Fosse Green Energy Development Consent Order – Deadline 4 Submissions

Planning Inspectorate Case Reference: EN010154

Indicative Layouts

EN010154/APP/6.2.

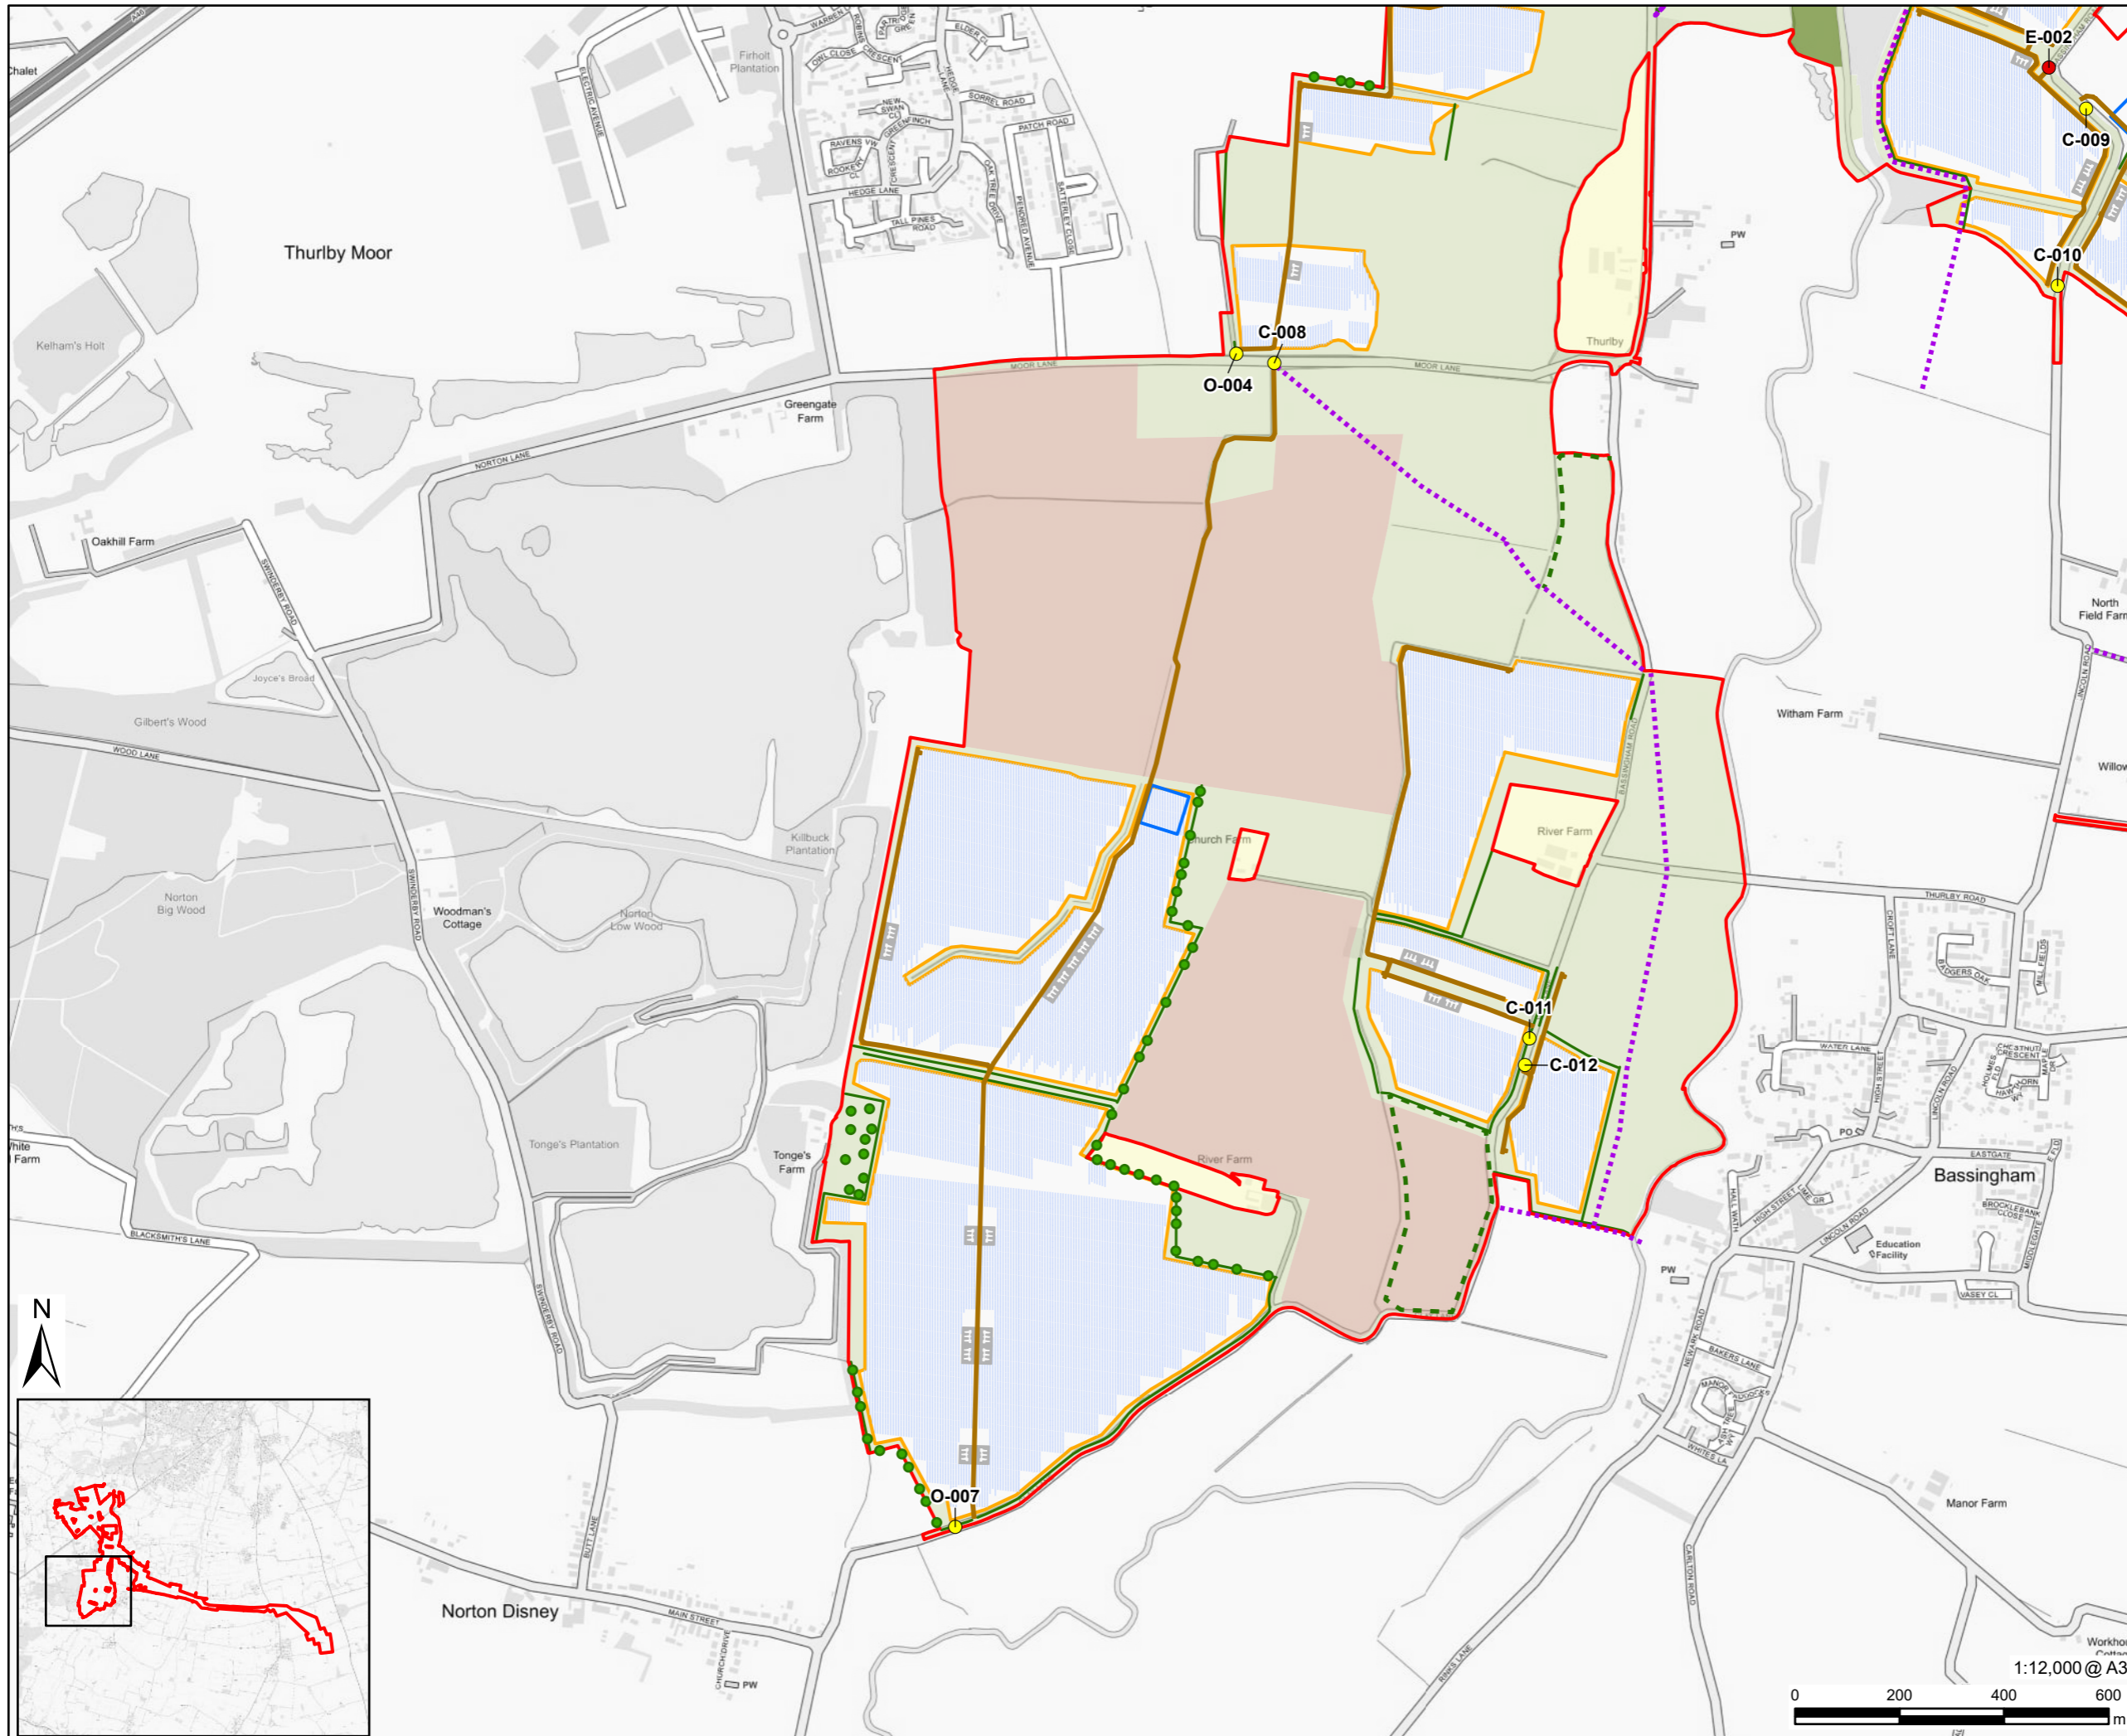
Figure 3-2A 'Indicative Fixed South Facing Layout' and 3-2B 'Indicative Single Axis Tracker Layout' have been updated and submitted as part of the Applicant's Deadline 4 submissions. The update includes additional permissive paths to facilitate the Stepping Out Routes referred to by North Kesteven District Council, enabling these to be walked during the operation of the Proposed Development. These permissive paths will be secured for the lifetime of the Proposed Development. The updates set out in Figure 3-2A and Figure 3-2B are as follows:

- a. A section of the Stepping Out Route to the south of Housham Wood will not be available, with alternative permissive paths provided that are located through grassland or arable fields rather than the existing farm track.
- b. A section of the Thorpe on the Hill Stepping Out Route will not be available, however there is alternative provision via a Public Right of Way.

The Applicant has also taken the opportunity to include within these Figures the changes previously presented in the Landscape Mitigation Plan (at Appendix A of the Framework Landscape and Ecological Management Plan) which formed part of the Change Request **[AS-123]** (the removal of solar in Field 46, the addition of new hedges near River Farm, and clipping of the Order Limits near Thurlby). The total length of the proposed permissive paths following this change is now 10.2km. The total length of the Stepping Out Routes within the Order Limits that are not currently PRow is 1.8km. The net difference is therefore 8.4km.
